Bicester Gateway Phase 1b RMA

Response to OCC Comments on Application

Project: 226701

By: FC / Date: 22/09/22

DRAWING NUMBER: 226701_PD01_AT01	REVISION: .
----------------------------------	-------------

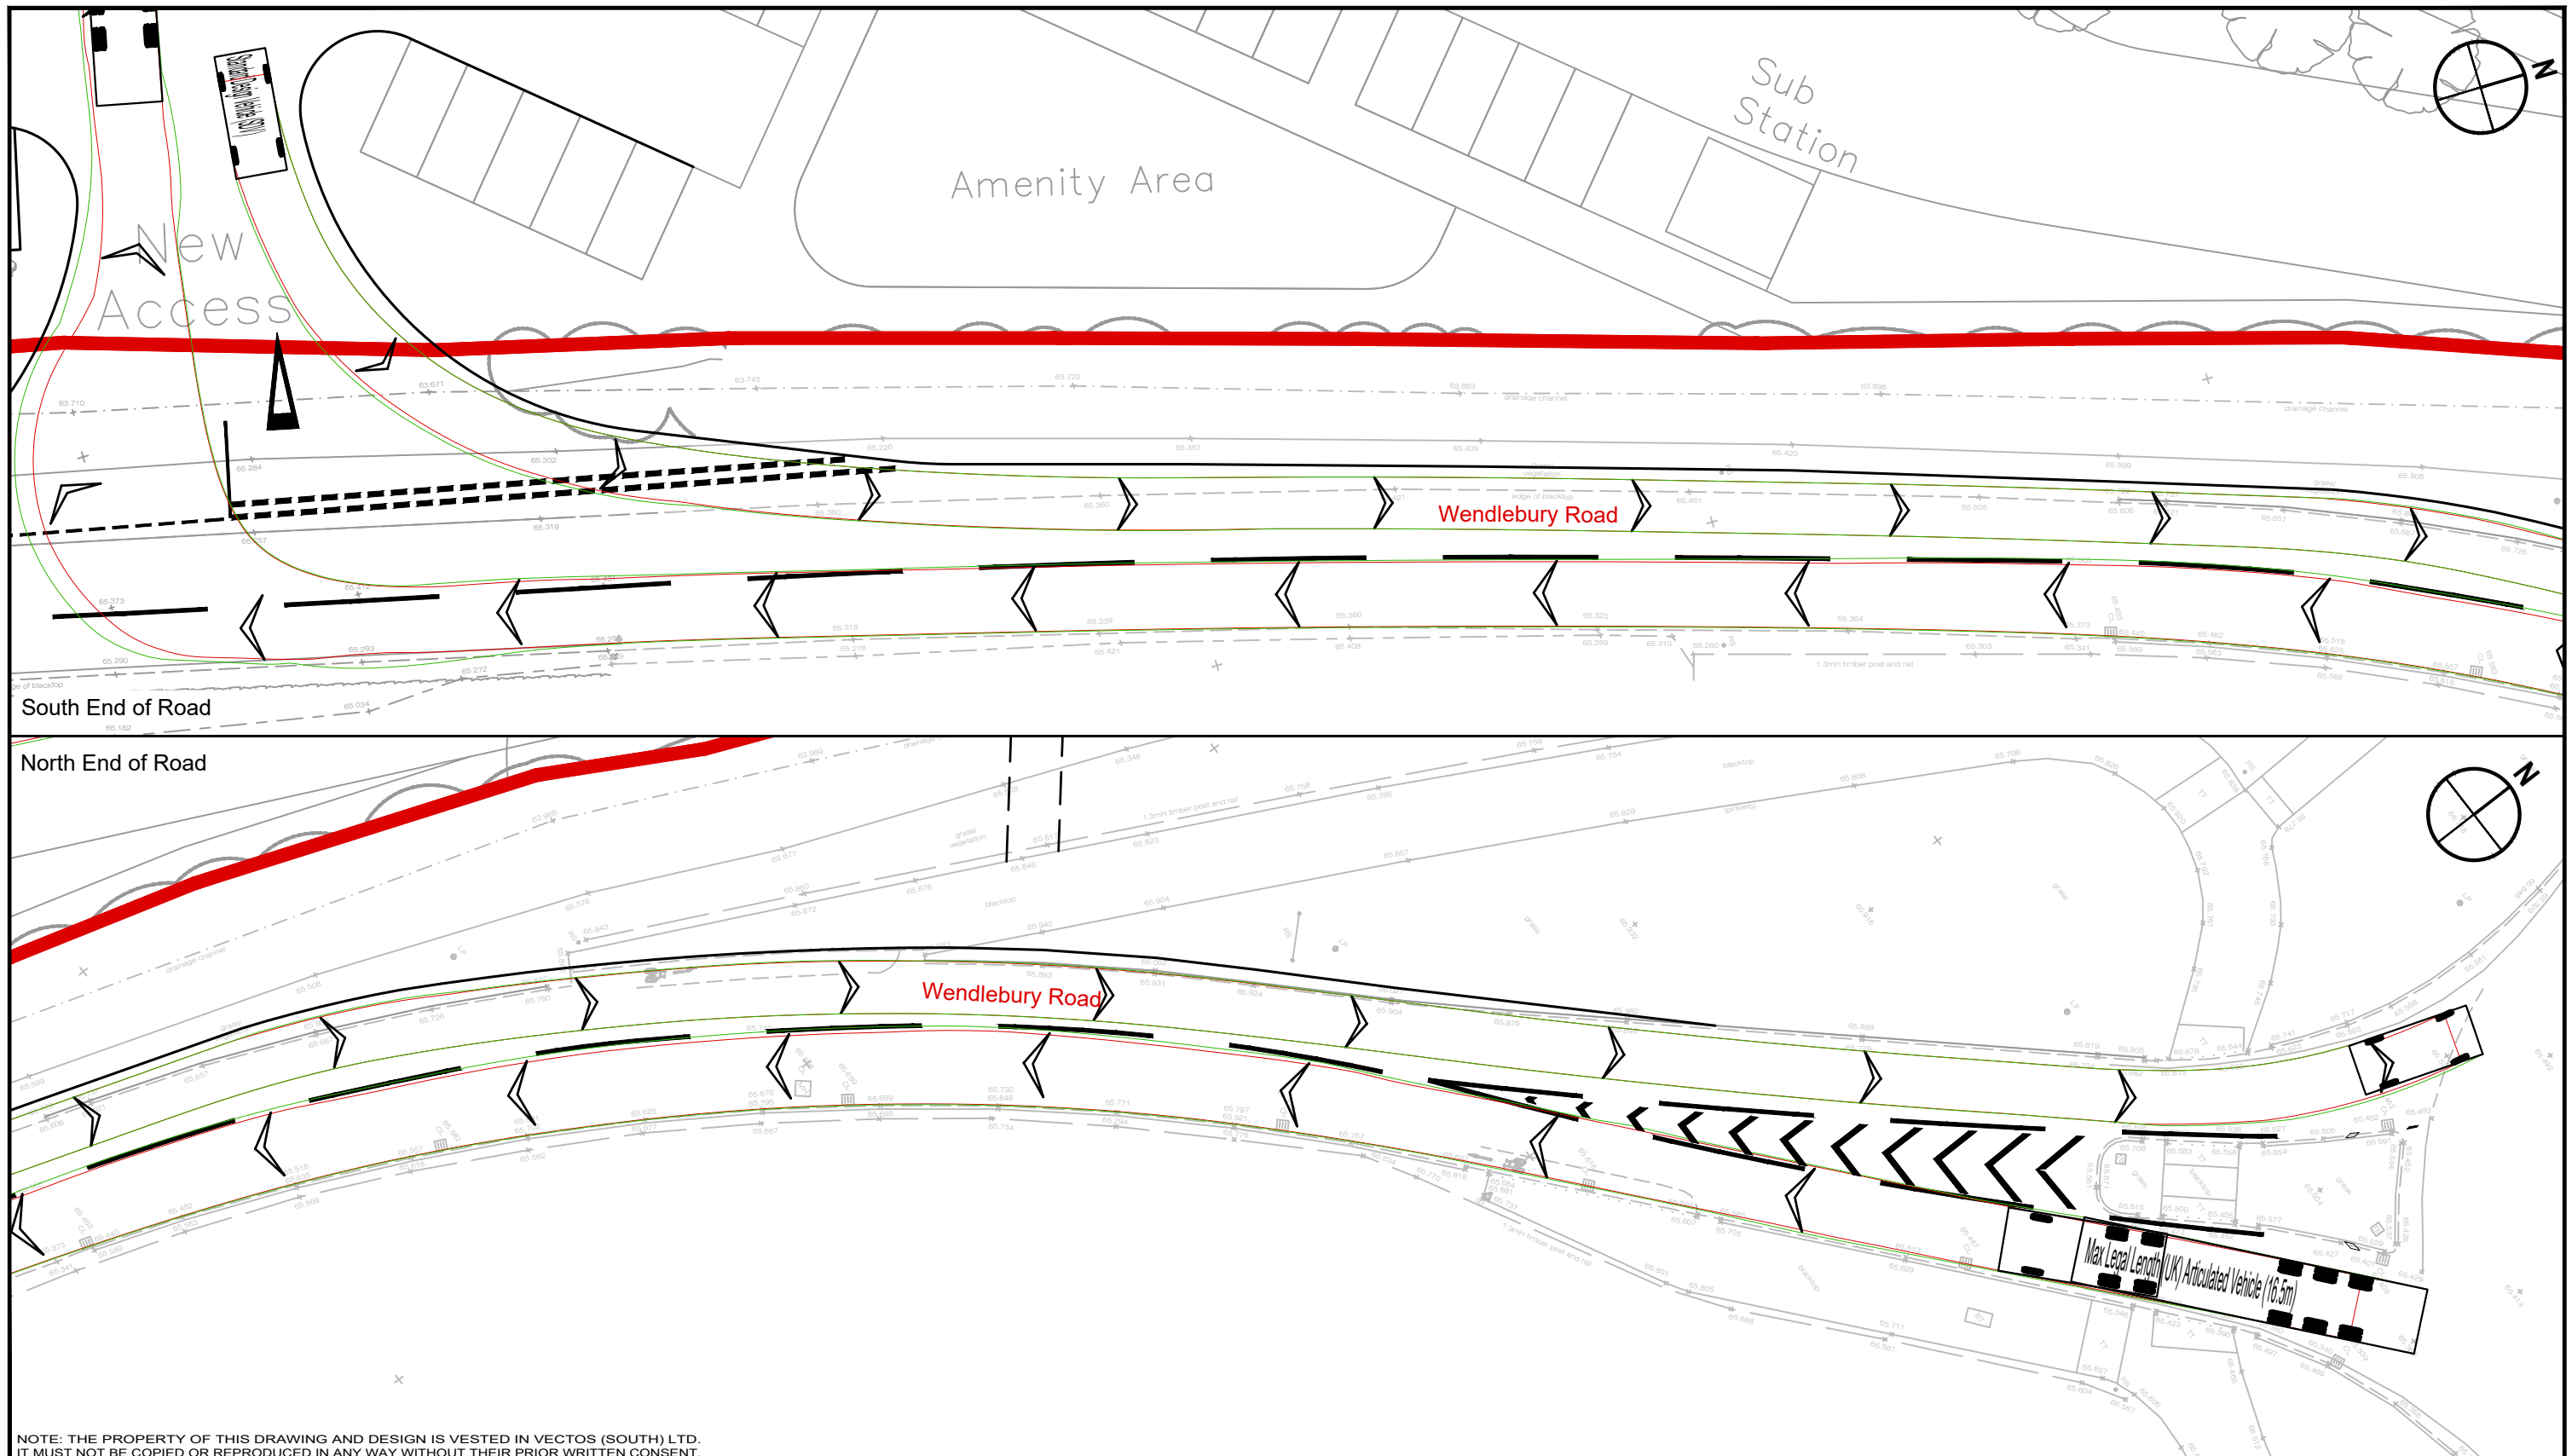
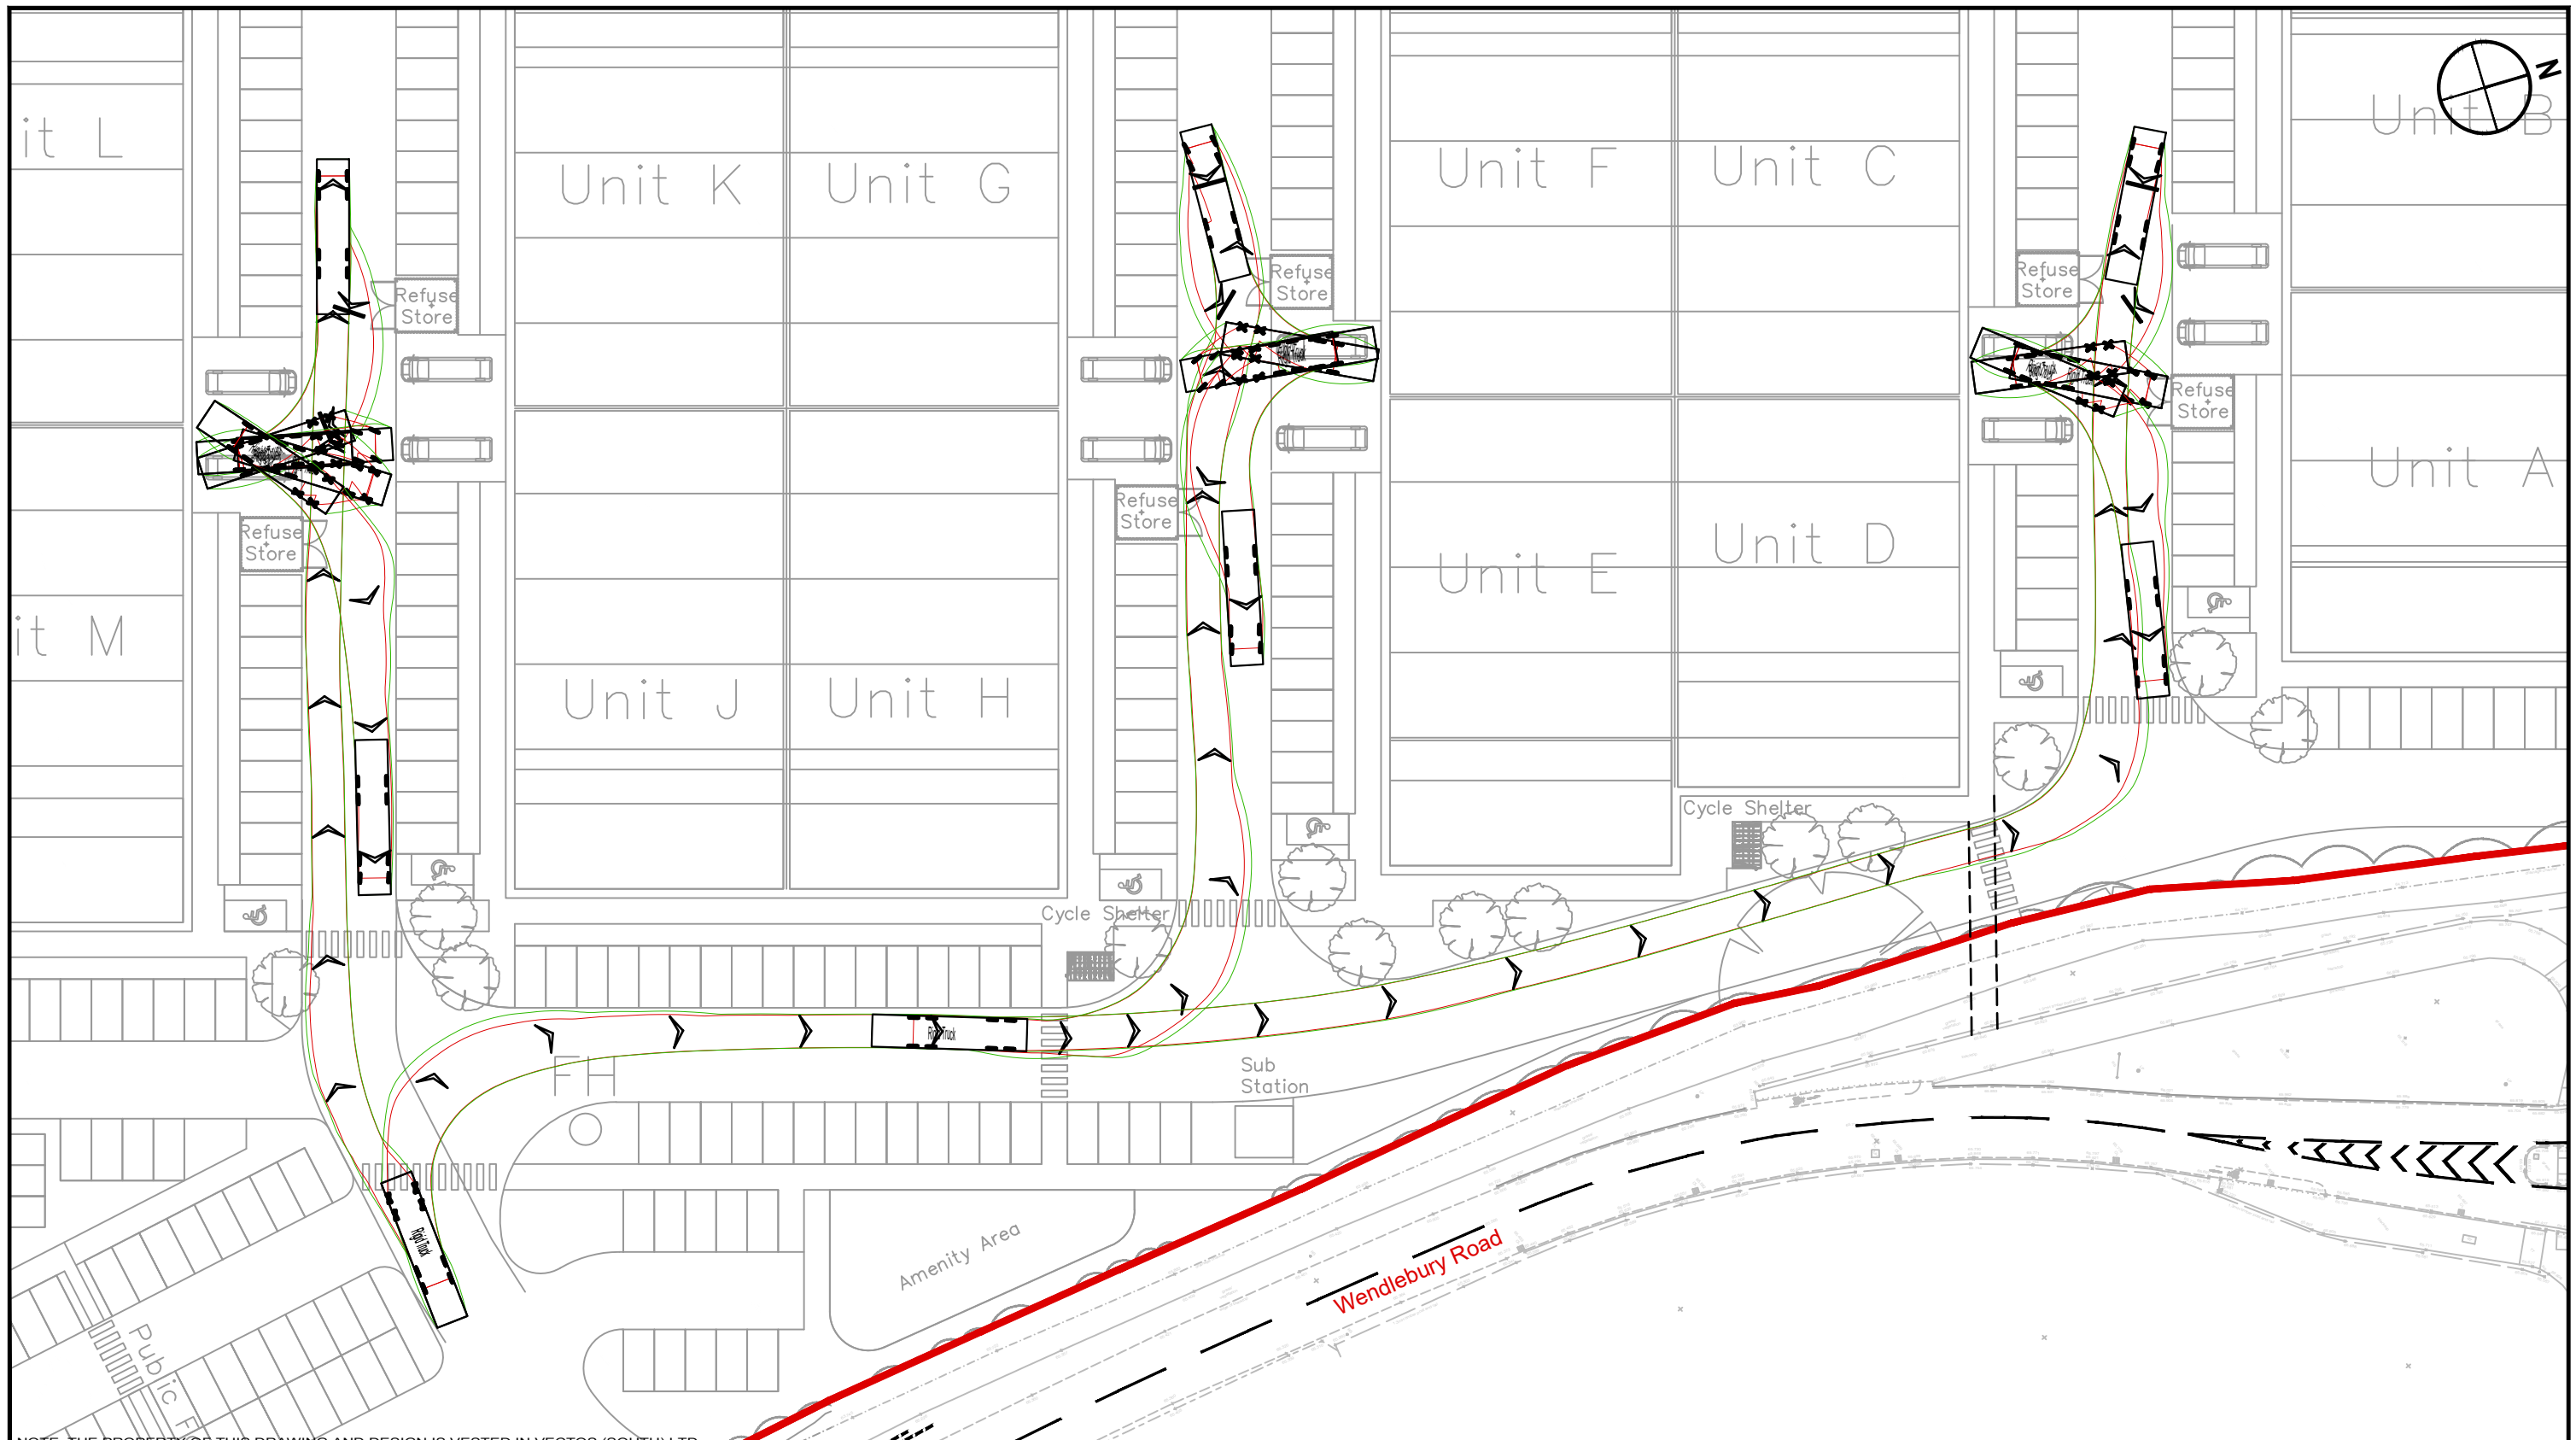
HGV tracking should be provided for entrance and exit of site. **Reason for objection.**

31. Drawings providing vehicle swept path analysis for a box van, a refuse vehicle, a 12m flat-bed lorry, and an articulated lorry are provided in the Transport Statement accompanying the Reserved Matters Application, in Appendix F. These drawings demonstrate that the proposed development can be accessed by a range of servicing vehicles to meet the requirements of prospective tenants on site. There is no need to provide this information again.
